PARKS AND COMMUNITY SERVICES DEPARTMENT

May 23, 2024

Subject: Grandview Reserve Phase III PUD Development Plan and Preliminary Plan (PUDSP-24-001)

SHEET

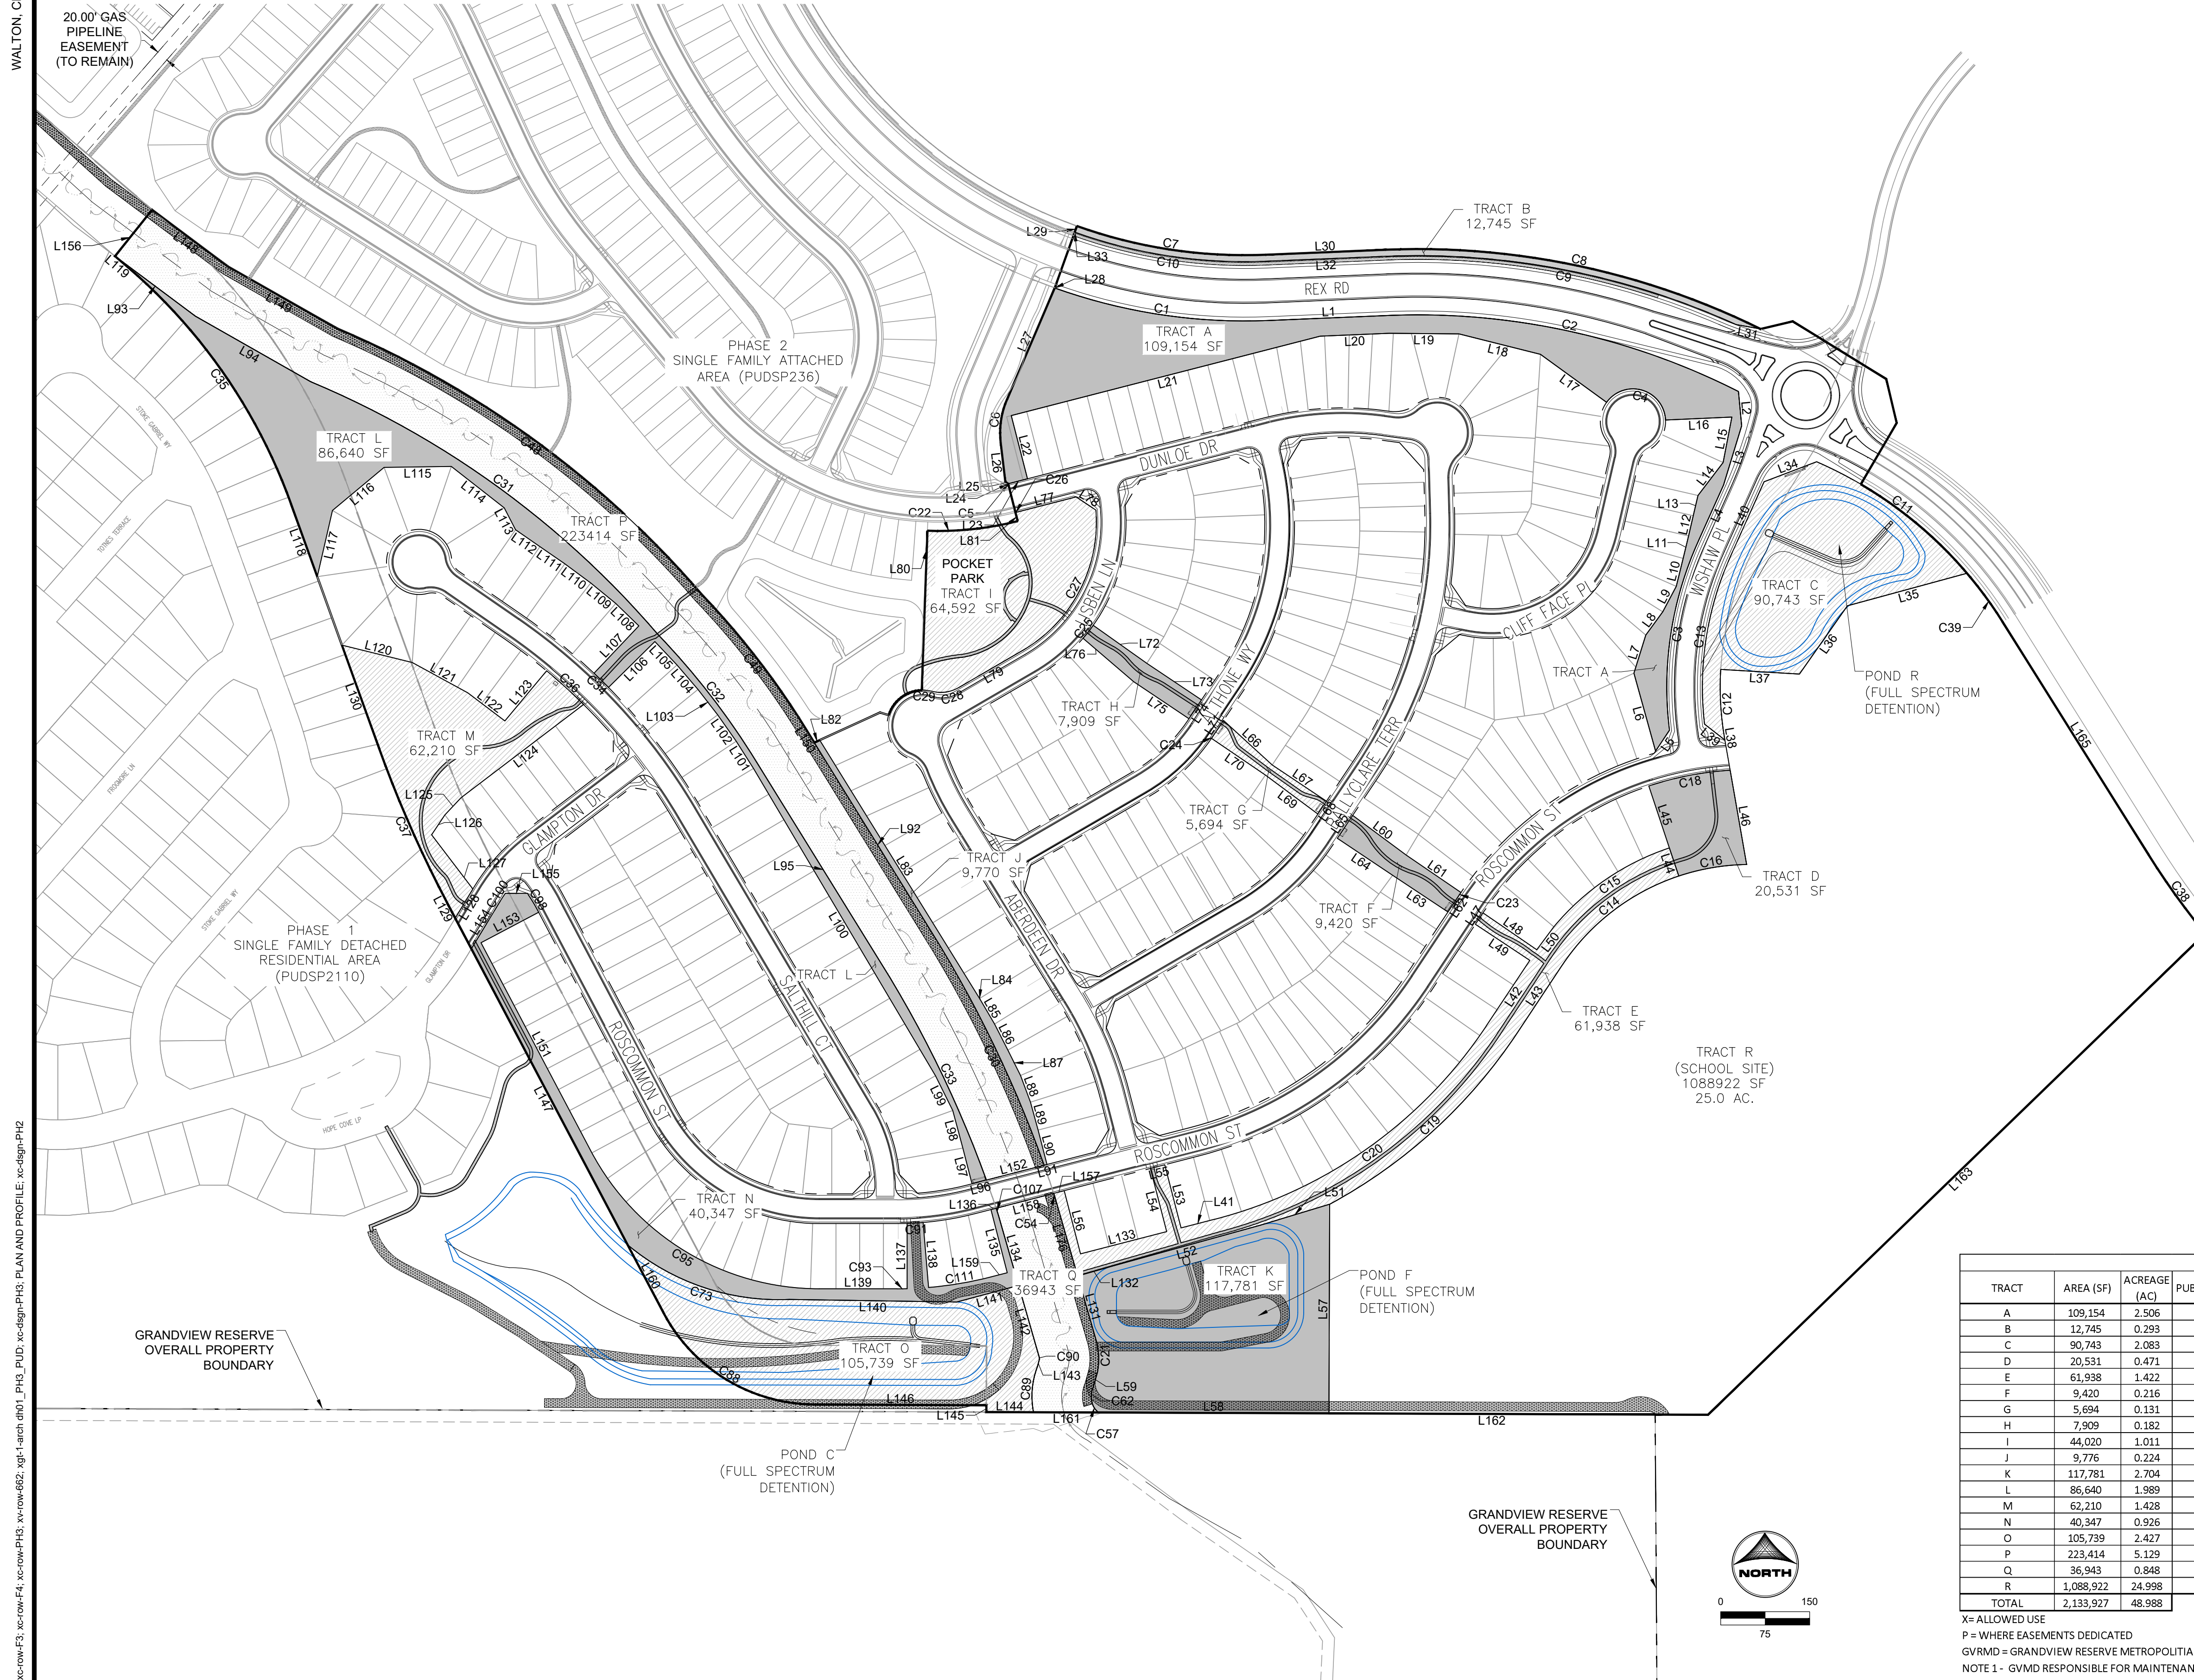
However, the Land Use Table shown on the first page of the PUD Development Plan and Preliminary Plan, however, does not properly list all the available open space, and only highlights the neighborhood park tracts, thus inaccurately showing that the project does not meet the Land Development Code's 10% open space requirement. Staff highlighted and calculated all tracts that meet the definition of open space, which include the neighborhood parks, passive open space, trail corridors, and landscape areas. Staff spoke with the applicant's representative, and they verified the staff's findings. As such, the application has met and exceeded the 10% open space requirement.

SHEET
L.08
23

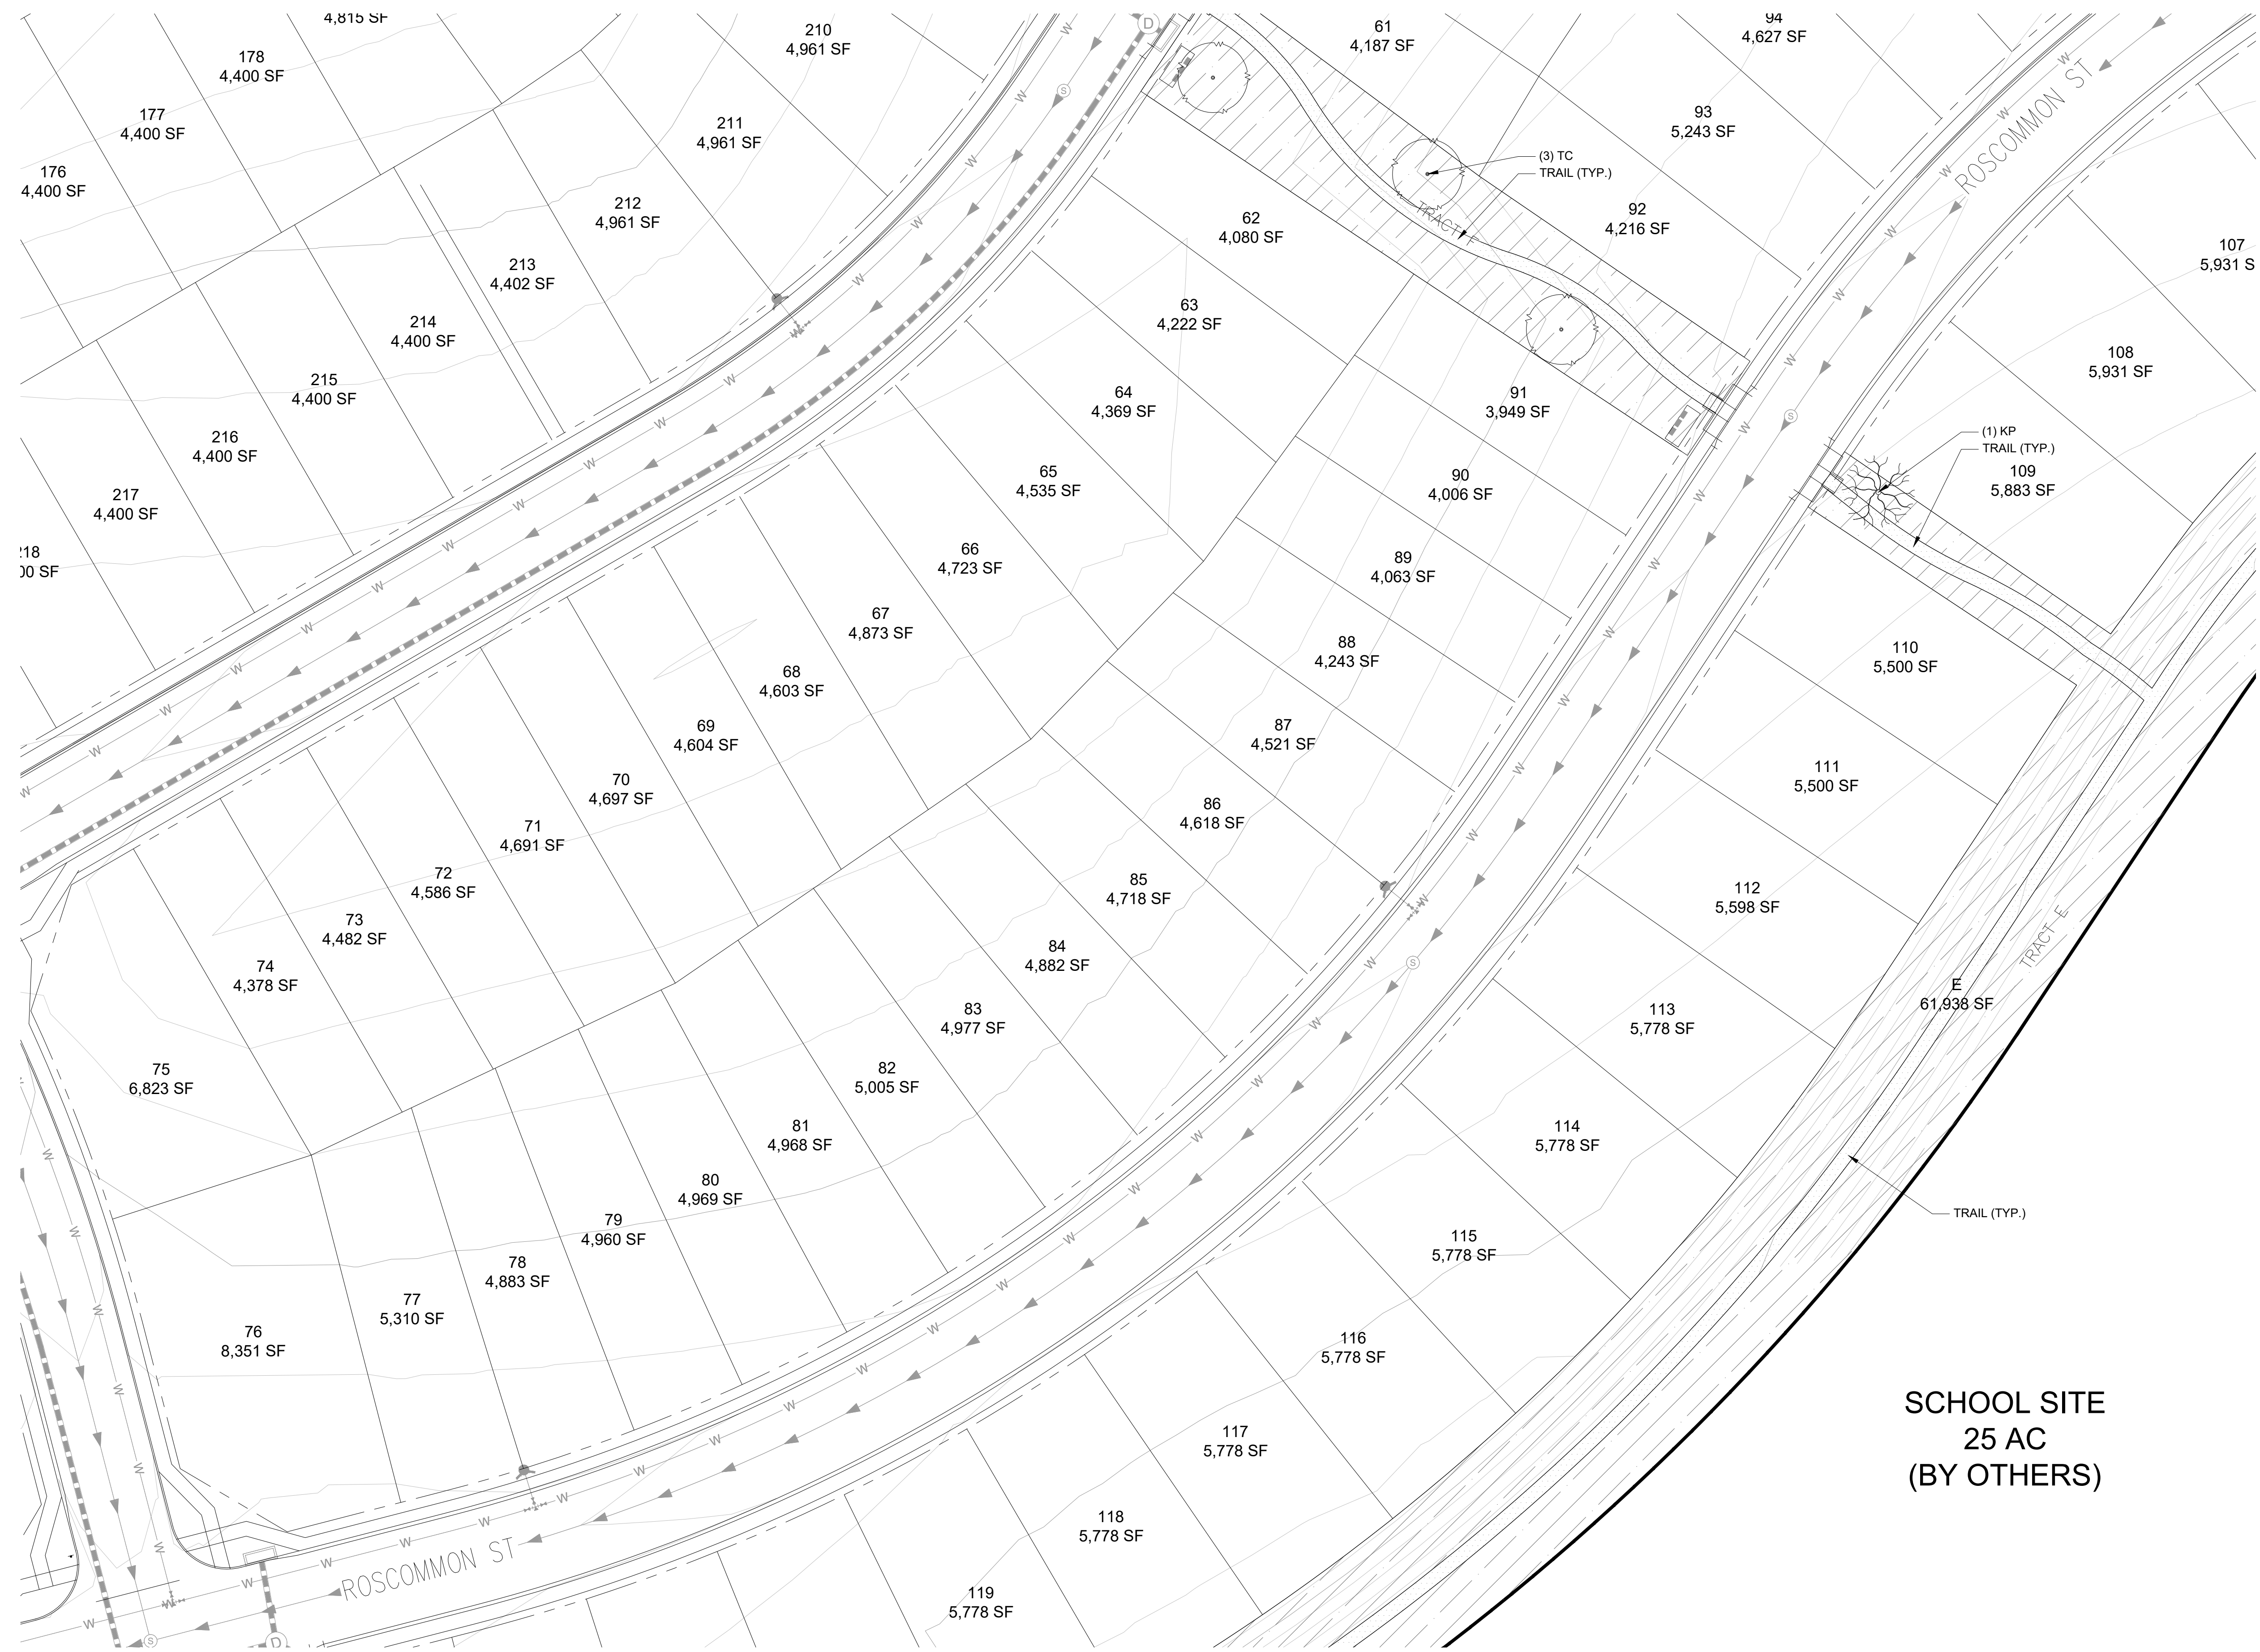
EPC staff is encouraged by the applicant's willingness to provide extensive recreational amenities for its residents of Grandview Reserve and citizens of El Paso County through the development of an expansive and connected park, trail, and open space system. Staff recommends that the applicant submit detailed site plans for the proposed neighborhood parks and include multi-generational recreational amenities such as a playground, multi-use turf field, and/or seating and picnic areas. The submitted Landscape Plans are rather limited and only show half of the proposed park area located in Tract I.
